Harnett County Government Complex  
307 W. Cornelius Harnett Boulevard  
Lillington, NC 27546

Rosita Dianne Jernigan  
204 Saddle Lane  
Lillington, NC 27546

**RE: Harnett County Land Use Application for Existing Tank # 09-5-22240R**

Lot 13 Johnson Farms S/D

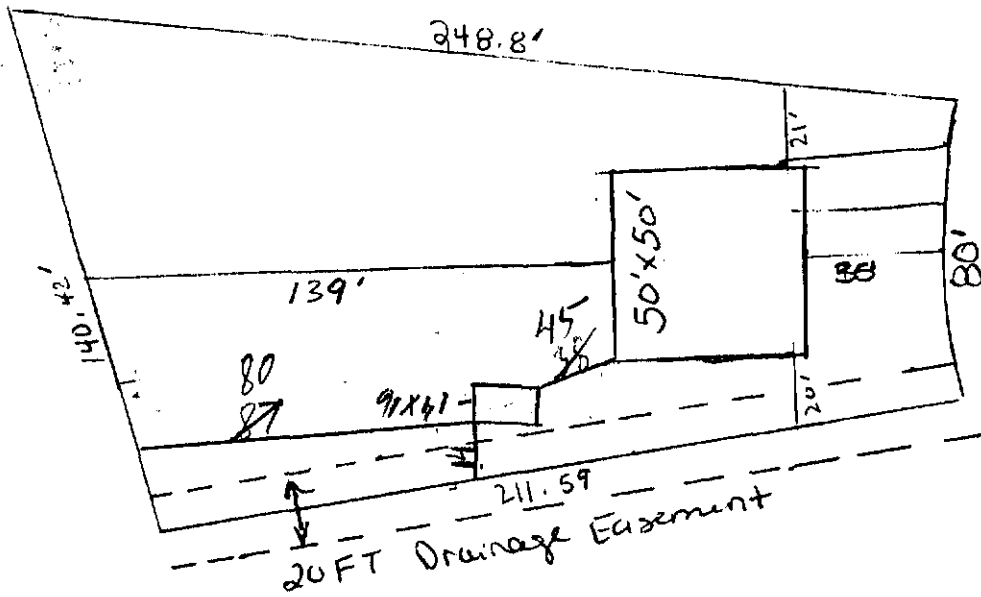
Based on the criteria set out in Title 15A, Subchapter 18A, of the North Carolina Administrative Code, Rules .1950, the evaluation indicated that the site is **UNSUITABLE** for the addition requested. Therefore, your request for an existing tank is **DENIED**. The site is denied based on the following:

- 15A NCAC 18A.1950 a(16) Any swimming pool must be 15' from any part of septic system.
- 15A NCAC 18.1945 (b) Each lot shall have original septic system plus repair area.
- 15A NCAC 18A.1950 (10) –Any building to be 5' from drain line. Your proposed building *may* be on the drain field. Call me at the number listed below to discuss my concerns. (This is regarding your revision that I have received)
